Date: September 16, 2024

FROM: Margaret Haynes, NMDOT Assistant District 3 Traffic Engineer

SUBJECT: Carlisle Forty Redevelopment Project Traffic Impact Study
South of I-40, southwest corner of Carlisle Blvd. and Indian School Rd
Albuquerque, New Mexico

The NMDOT received the TIS dated July 2024. District Three's comments are below.

TRAFFIC CONTROL SITE PLAN

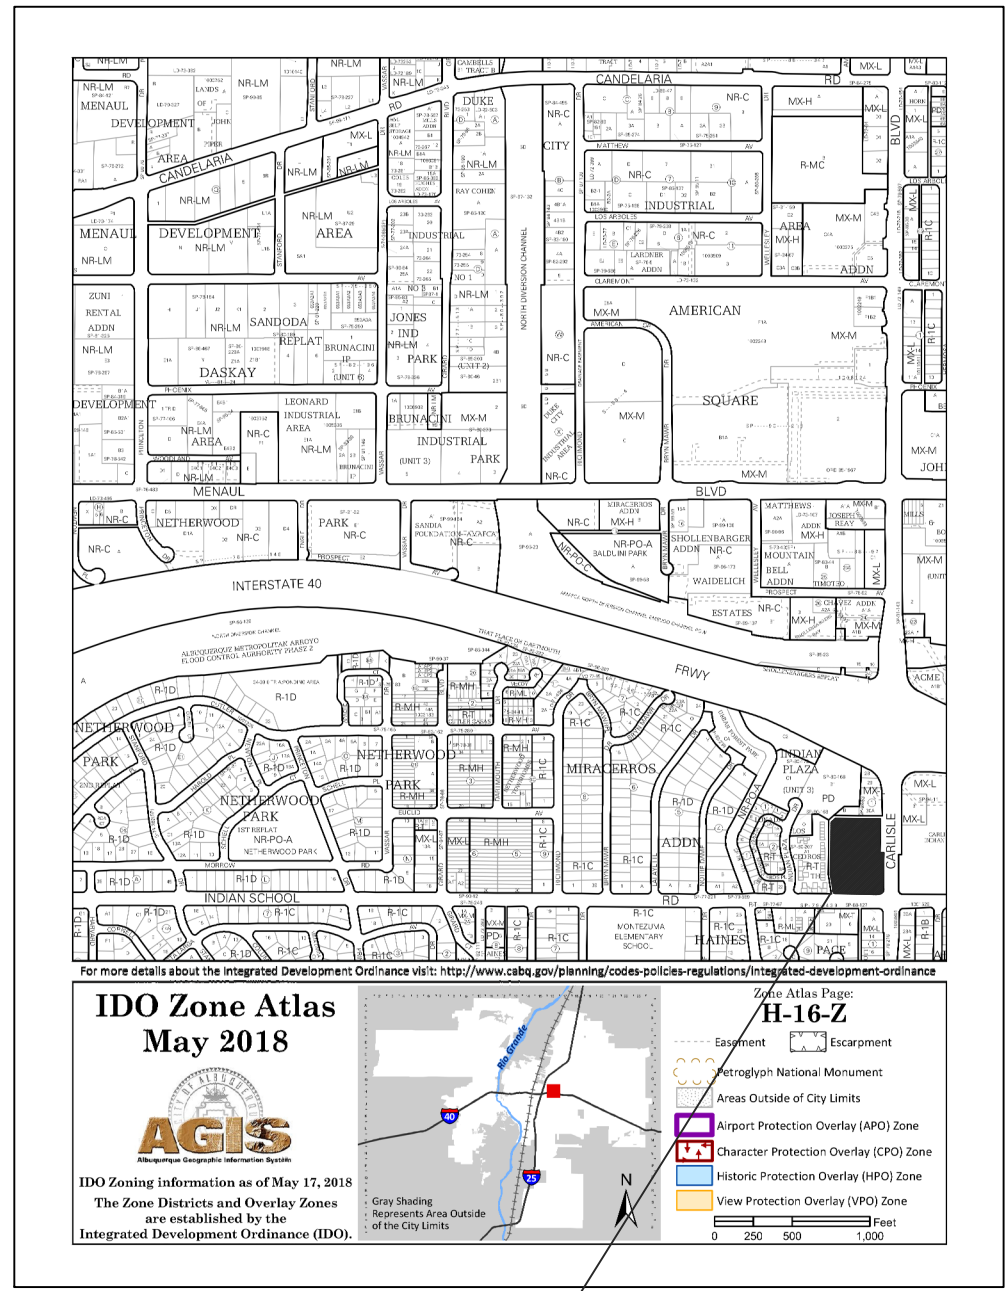
NMDOT recommends that full access "3" should be limited to a right-in/right-out/left-in only. See exhibit 1 next page for location. Both sites have access to the signal at Indian School and Carlisle via on-site circulation, which will allow a left movement. Please provide exhibit of access spacing from eastbound off-ramp to access points.

- Eradication and restripe or roadway widening to accommodate a bike lane for southbound Carlisle.
- Minimize access widths as much as possible for appropriate design vehicle for site.
- Potential median island to limit left-out access to Carlisle.
